EL PASO COUNTY STORMWATER MANAGEMENT PLAN CHECKLIST

Revised 5/21/07

**GRADING AND EROSION CONTROL PLAN**

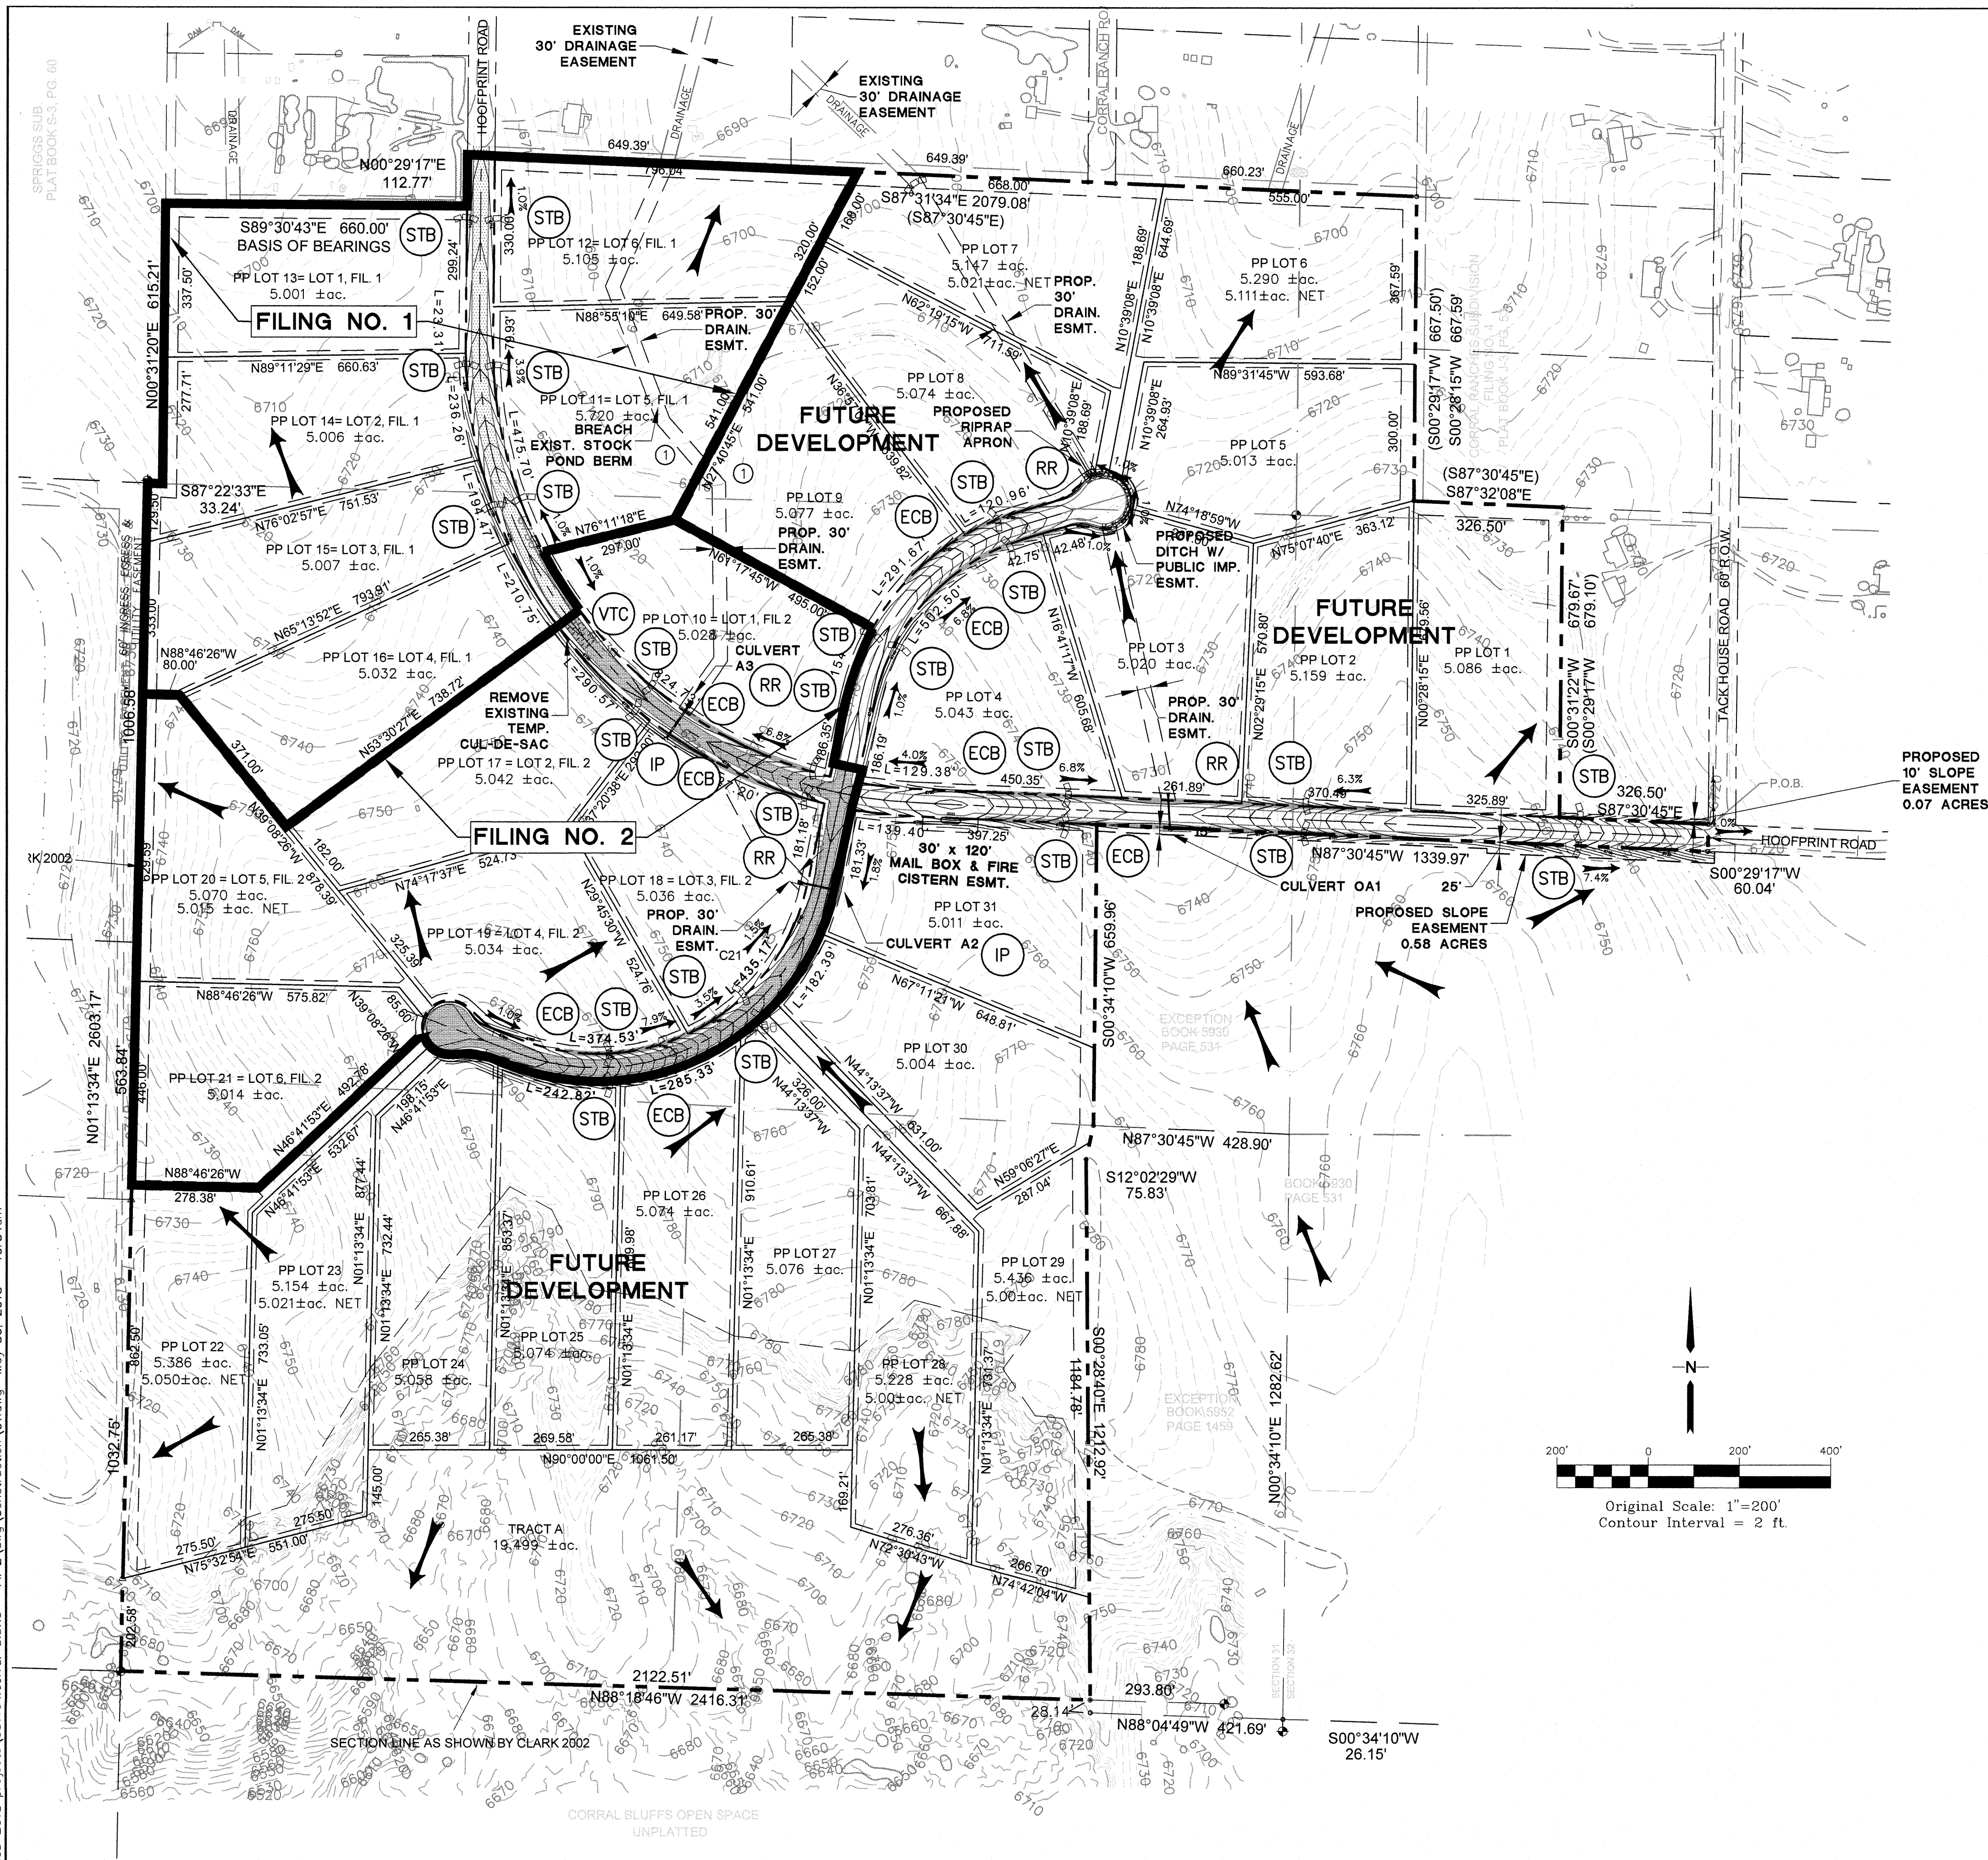
17) SWMP Map to include:

a) construction boundaries

Unresolved
06/20/2018

## EROSION CONTROL NOTES & DETAILS

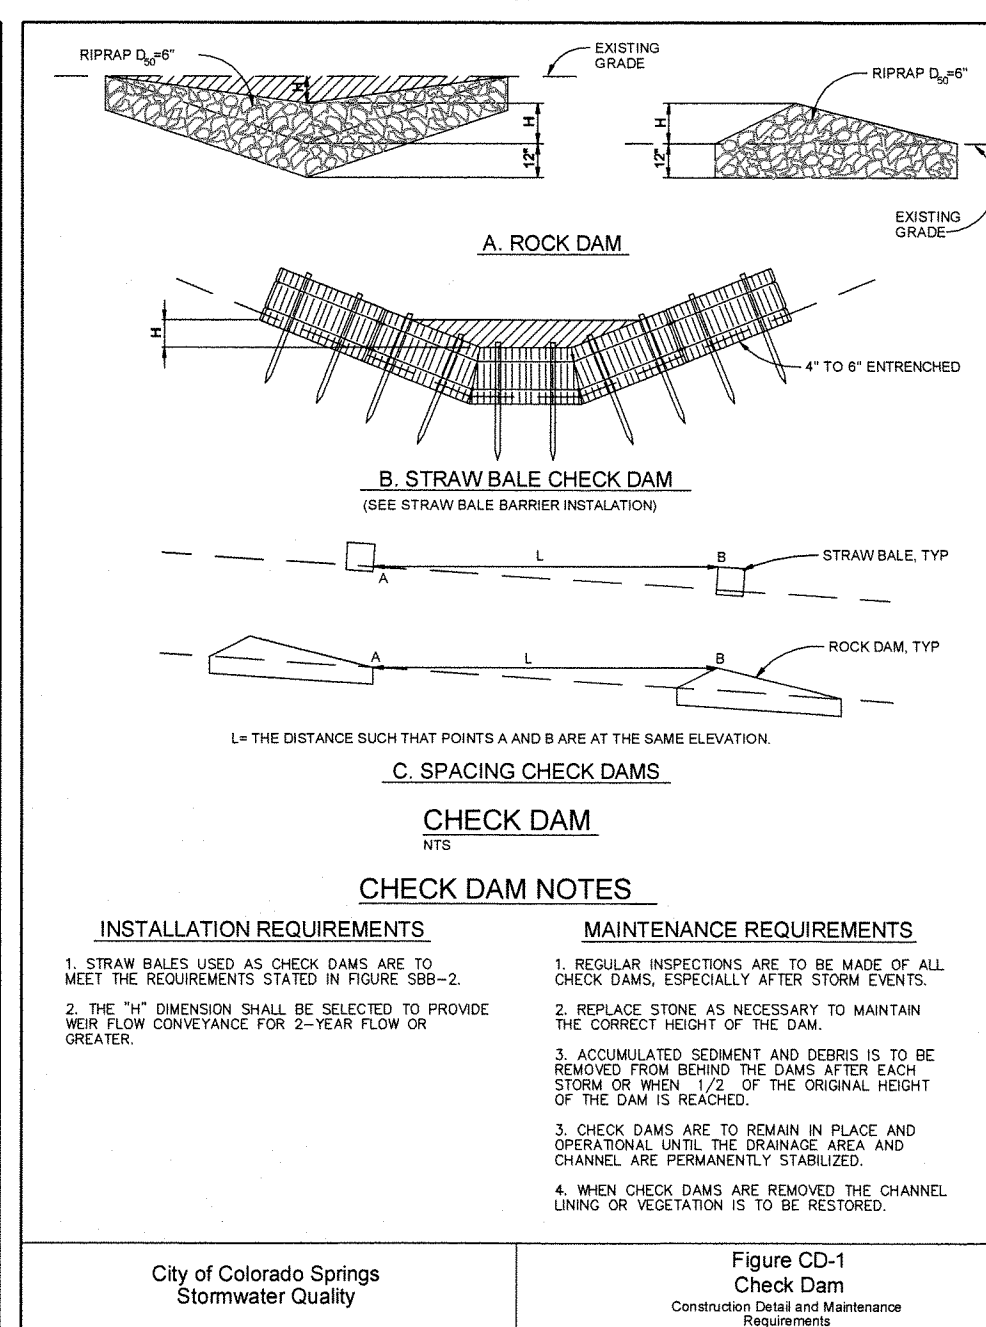
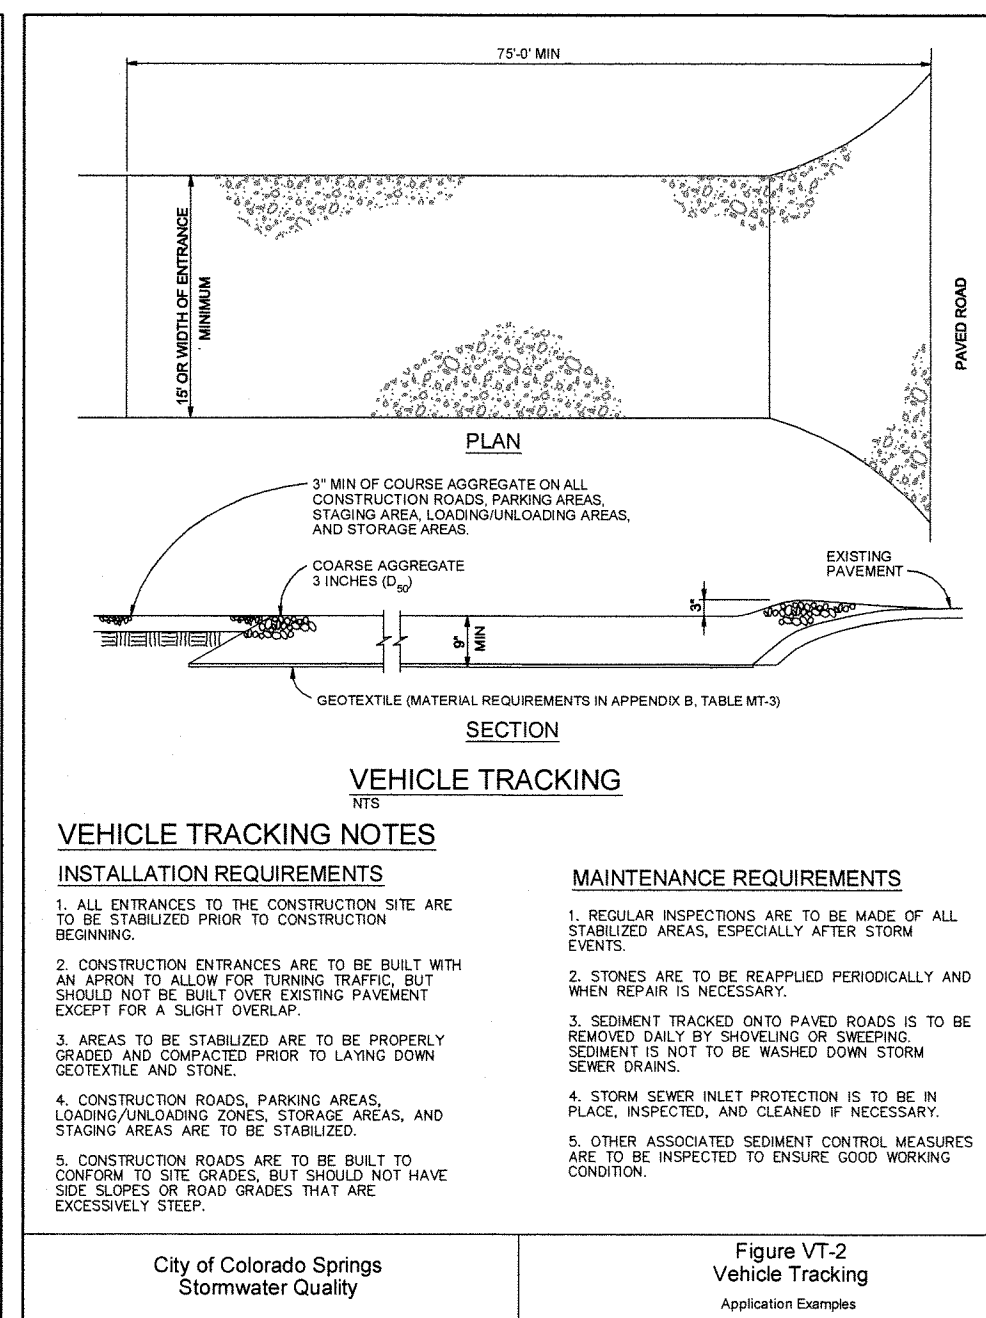
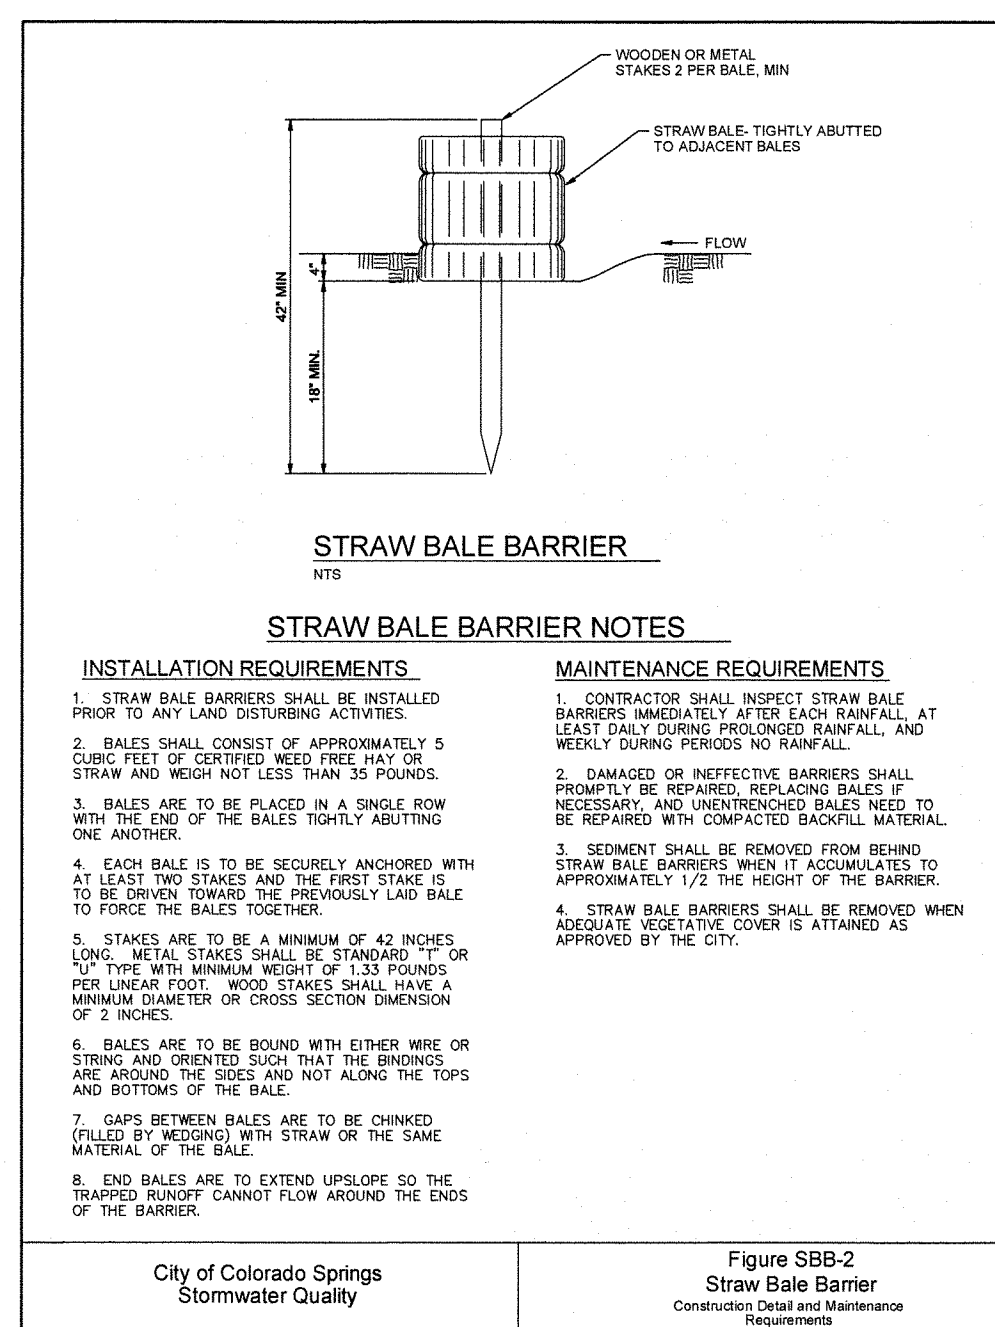
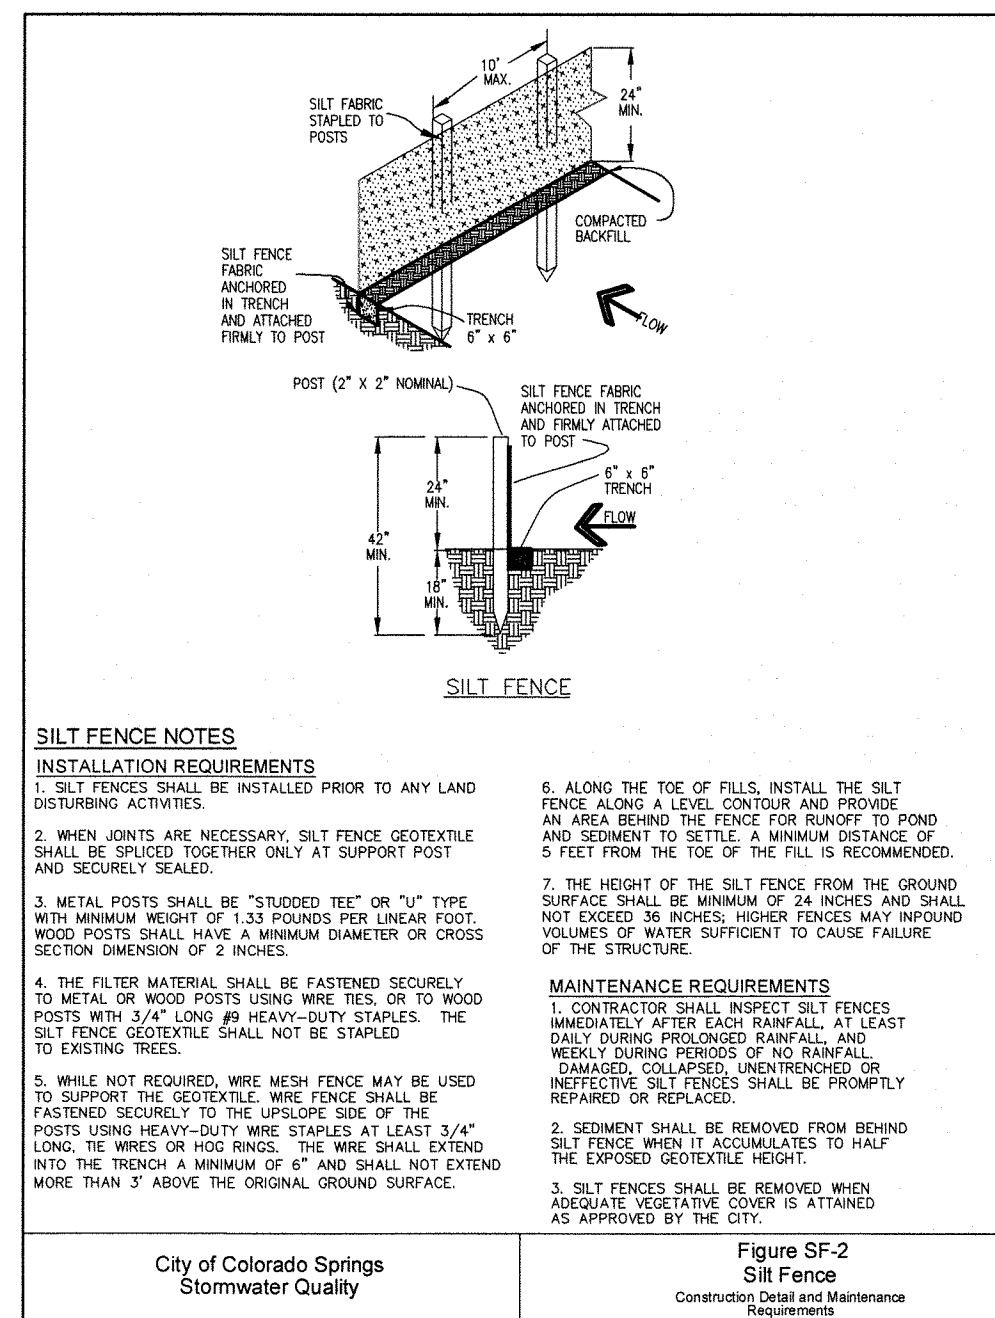
20) Technical drawing details for BMP installation and maintenance.

Unresolved
